**From:** Neville, Julie <Julie.Neville@lancashire.gov.uk>  
**Sent:** 10 December 2024 17:40  
**To:** Planning  
**Subject:** 3/2024/0981 Meargill Farm Holden Lane Bolton by Bowland BB7 4LZ  
**Attachments:** 3 2024 0981 Overlay.pdf

**Reference** 3/2024/0981  
**Related Application** 3/2024/0674  
**Location** Meargill Farm Holden Lane Bolton by Bowland BB7 4LZ  
**Proposal** Conversion of and extension of agricultural building to one self-build two-bedroom dwelling and formation of residential curtilage (resubmission of 3/2024/0674)

Existing site plan

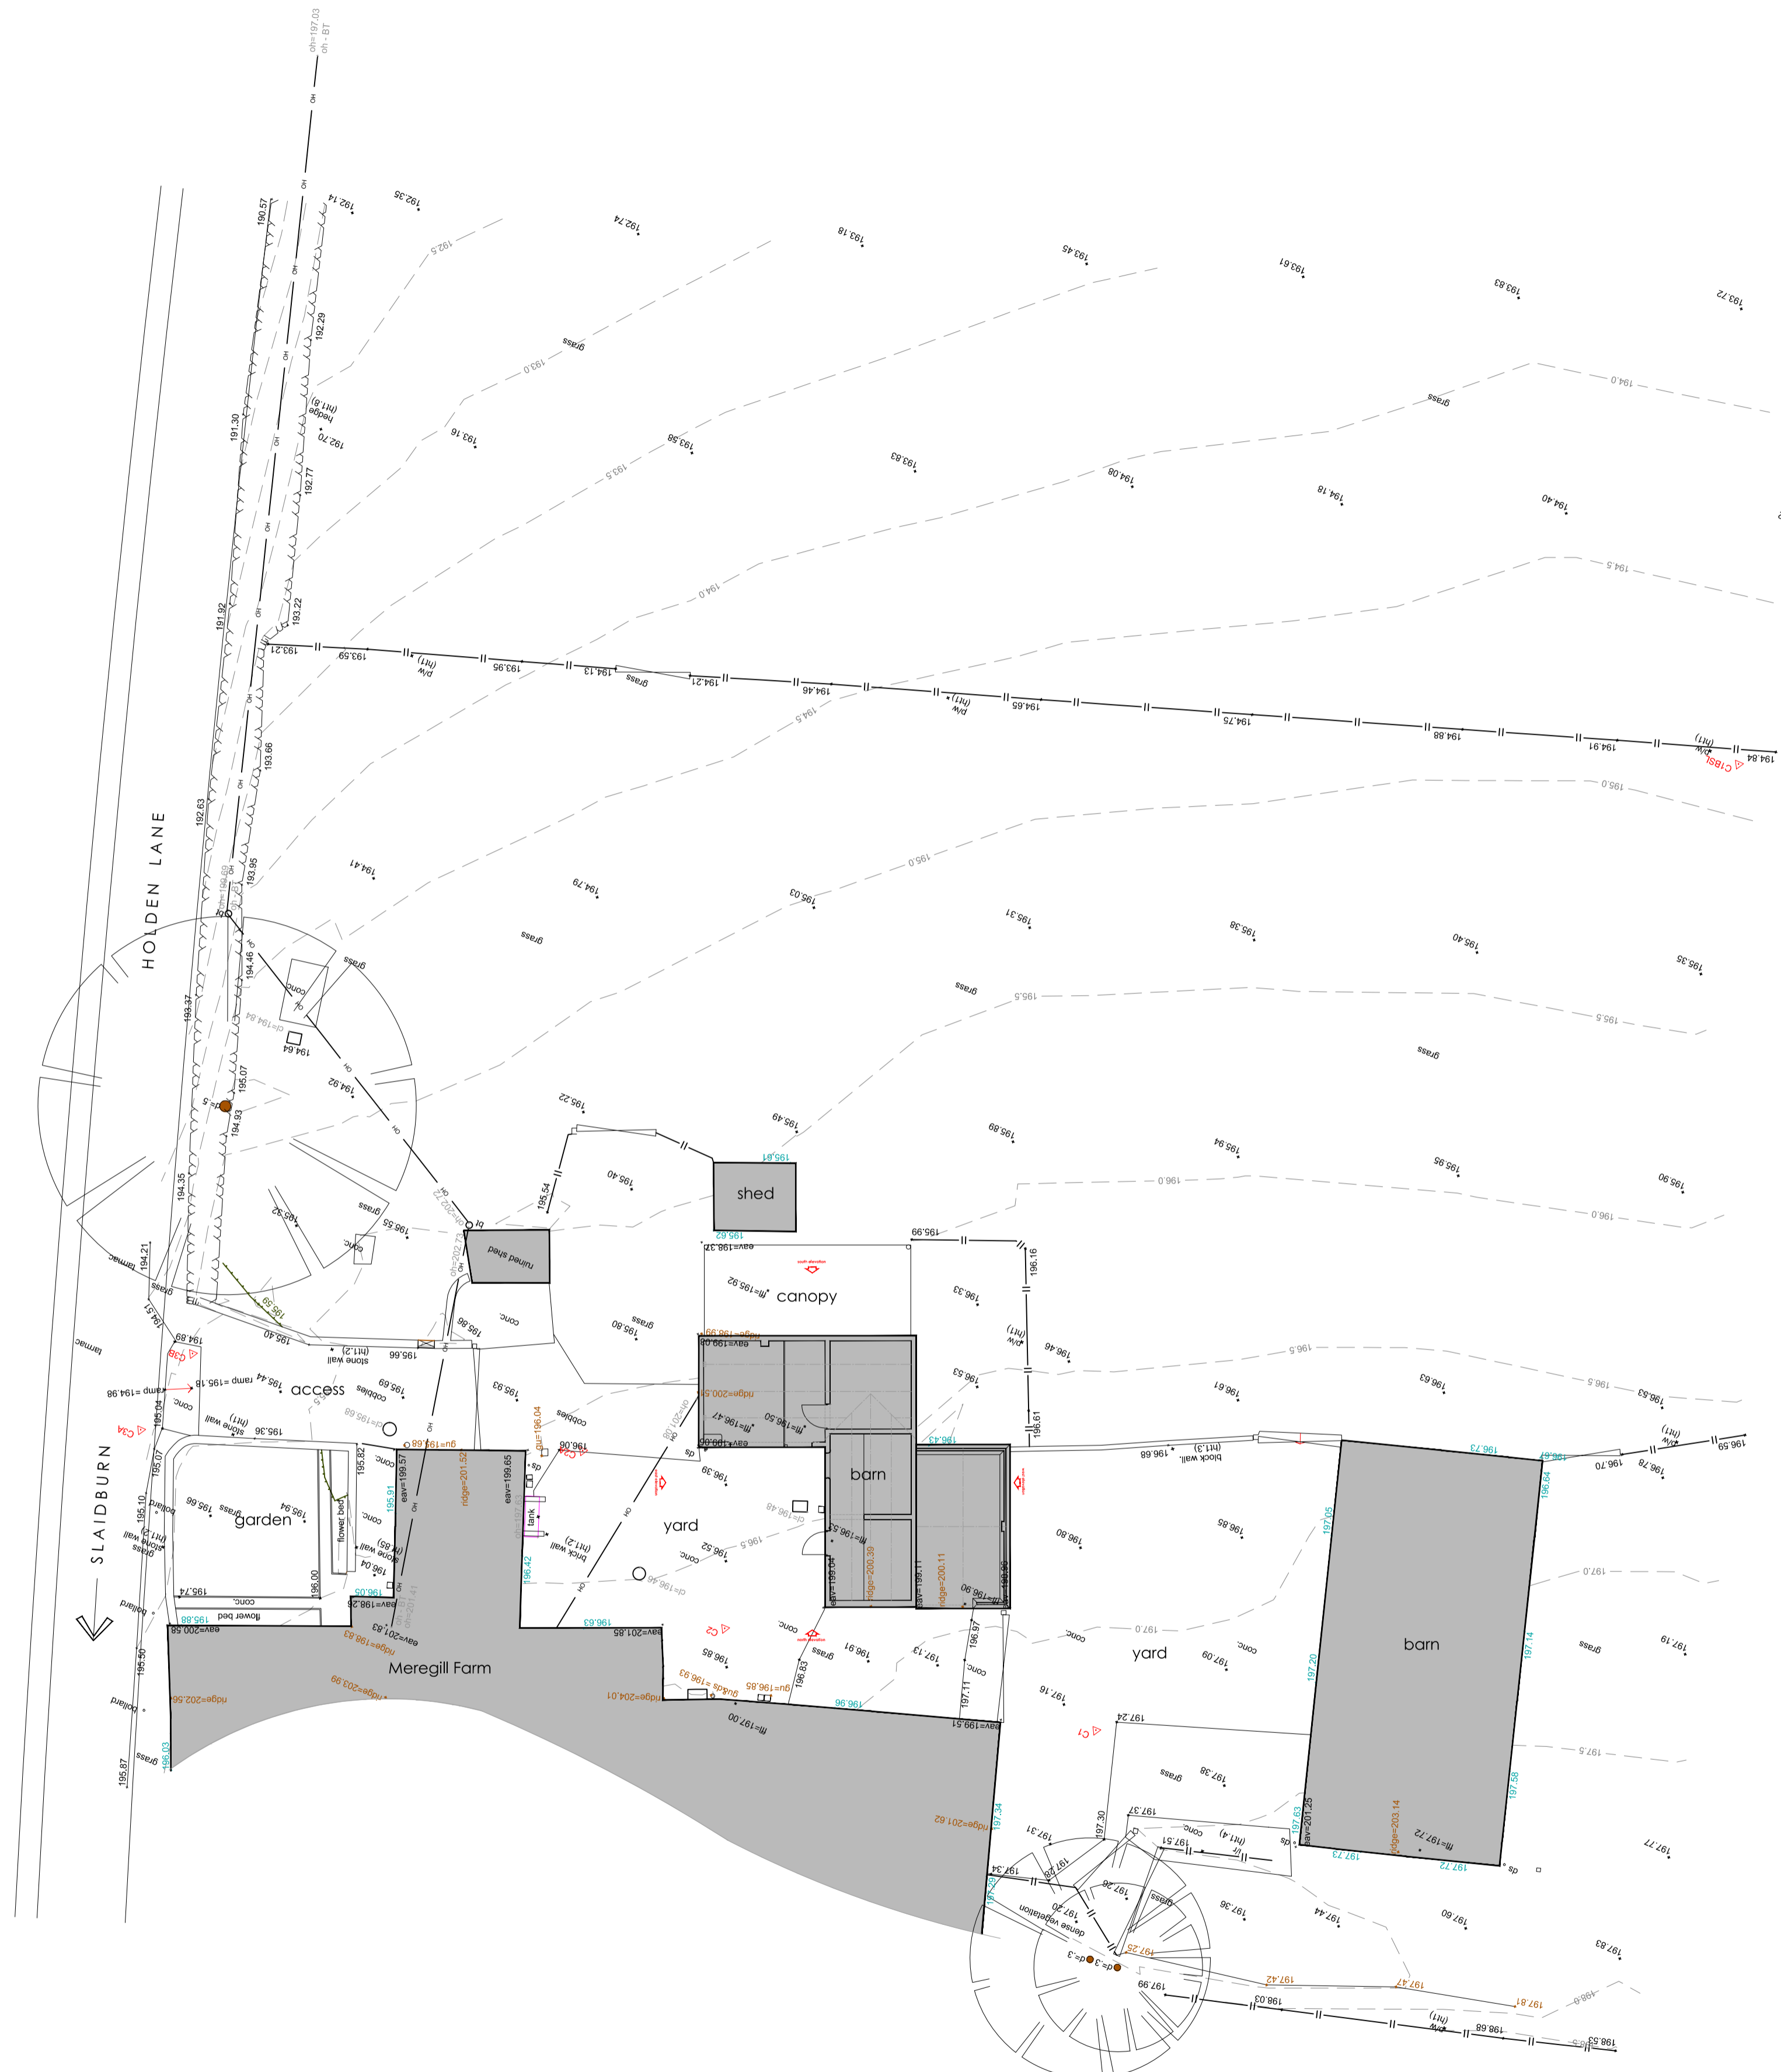
As was the situation with the previous application, although there is available width through the yard the existing building infringes onto the definitive line of footpath FP0307010 as was highlighted by the overlay. Any obstruction of a public rights of way is a criminal offence and something that would impact the sale and potential value of the property. This being so, the proprietors may wish to consider pursuing a Public Path Order under the provisions of Highways Act 1980 Section 119, administered by Lancashire County Council.

The detail of the exact alignment of the new route, the construction specification and any association works would need to be agreed with public rights of way before the necessary HWA80 S119 Order is made. I can advise that the new route must have a minimum width of 2 metres, have a firm constructed surface with no gates or stiles crossing the new route.
